Householder Proforma

2022/0138

1 Woburn Place, Dodworth, Barnsley, S75 3ST

Erection of single storey side extension to dwelling

Drawing Title
PROPOSED ELEVATIONS

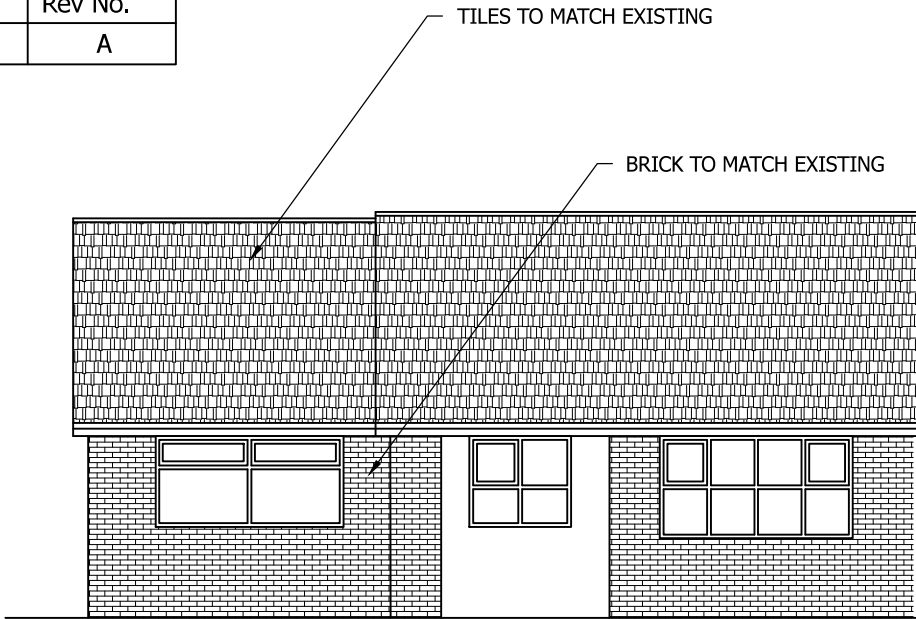
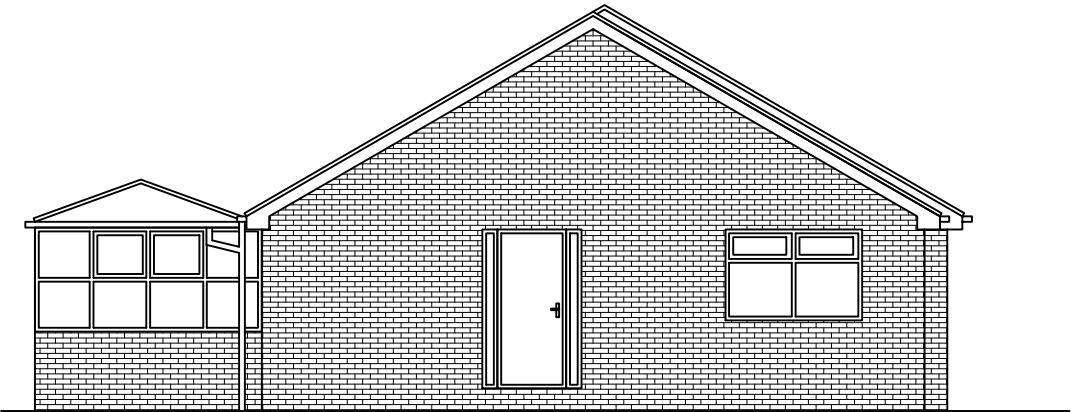
The applicant seeks permission for the erection of a single storey side extension to the western side elevation of the dwelling, the extension is to project 4m from the side elevation with a set back of 0.3m at the front elevation. the proposed extension is to be located on the side elevation of the dwelling facing the highway and therefore its inclusion would not increase levels of overshadowing or reduce levels of outlook to an unreasonable level. The property benefits from off-street parking whilst not a conventional arrangement the proposed extension does not result in the loss of off-street parking nor a requirement for additional provision.
